CLAREMONT BUSINESS PARK LOTS 1 AND 2 - FILING. NO. 1B

FINAL PLAT
CLAREMONT BUSINESS PARK
LOTS 1 AND 2 FIL. NO. 1B
JOB NO. 44-034
DATE PREPARED: 01/31/2020
DATE REVISED: 04/01/2020

FILE NO. PCD FIL. NO. VR-19-004

Final Plat_v3_redlines.pdf Markup Summary

FINAL PLAT  
CLAREMONT BUSINESS PARK  
FILING NO. 1C  
JOB NO. 44-034  
DATE PREPARED: 01/31/2020  
DATE REVISED: 04/27/2020

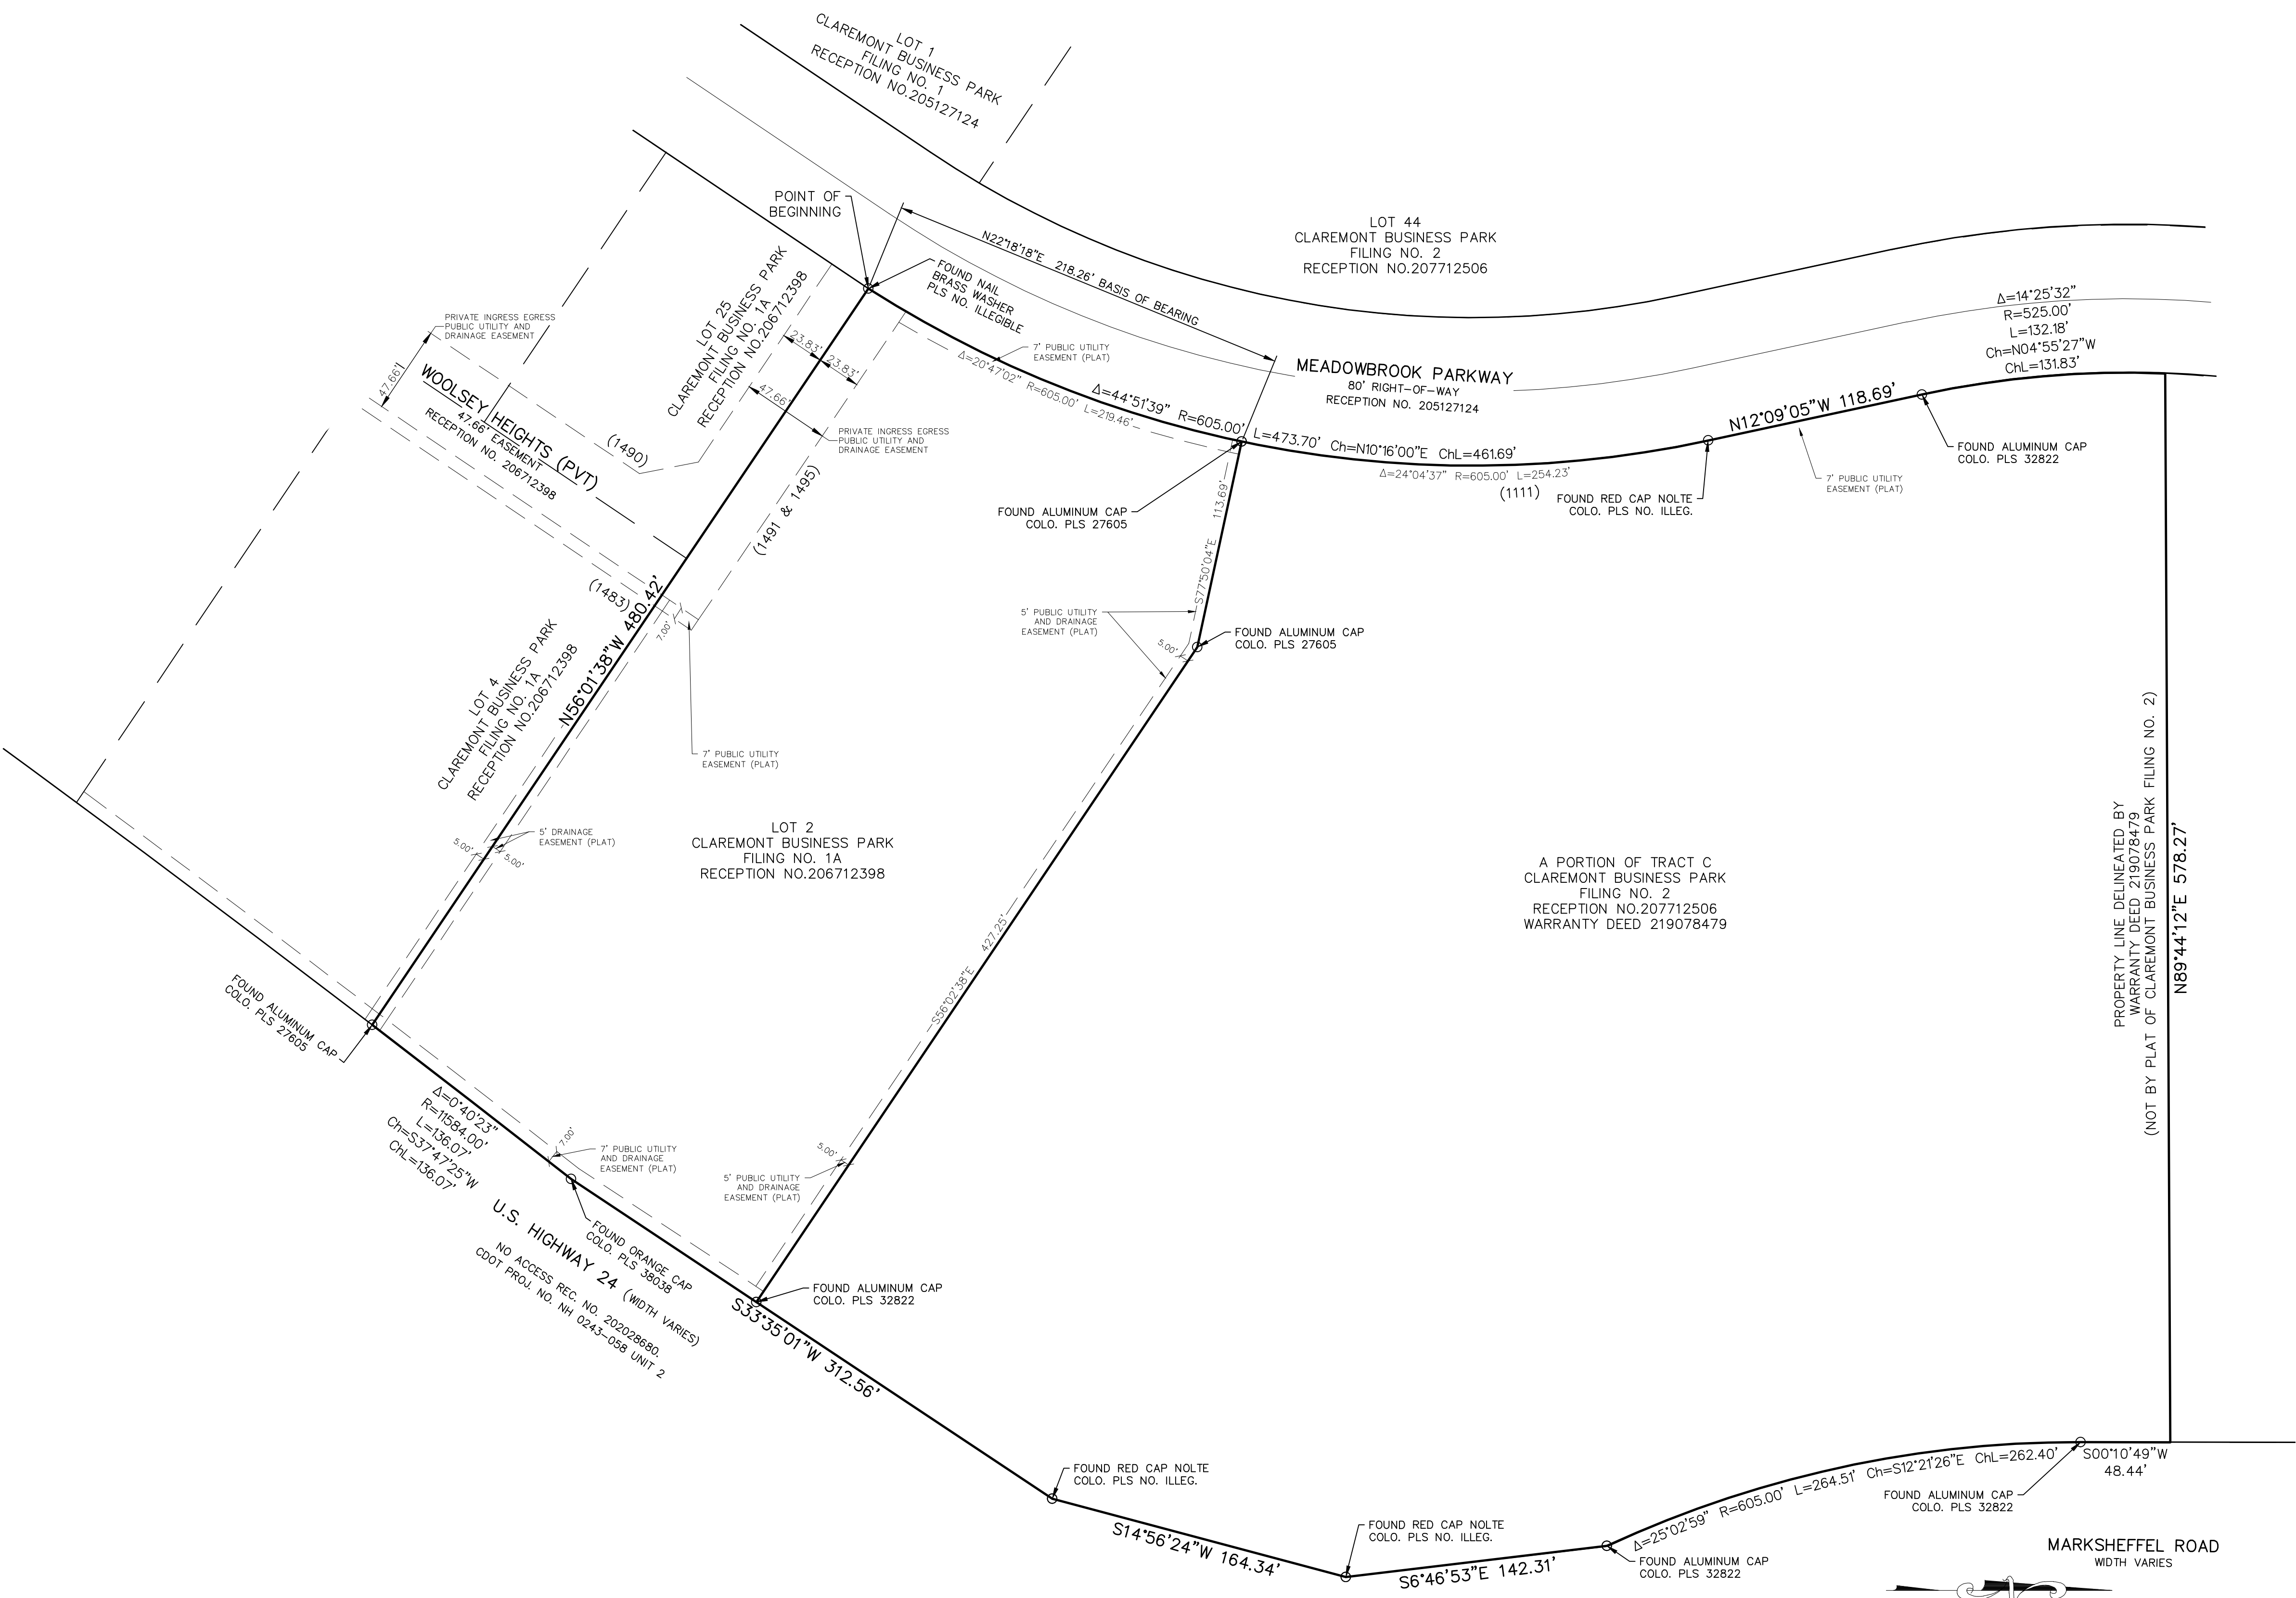
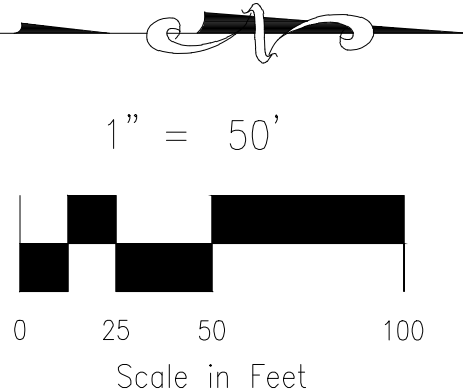
This easement line appears solid like a boundary line. Please revise since this is not dividing a separate lot.

If this easement is existing, it should be shown on the "as platted" drawing as well.

looks like it should be tract A and that the tract C should be deleted

add plat note reference

The tract should be labeled and named as replatted instead of using the previous naming convention.

include acreage of all lots as well as sq.ft.

this is confusing. Please remove
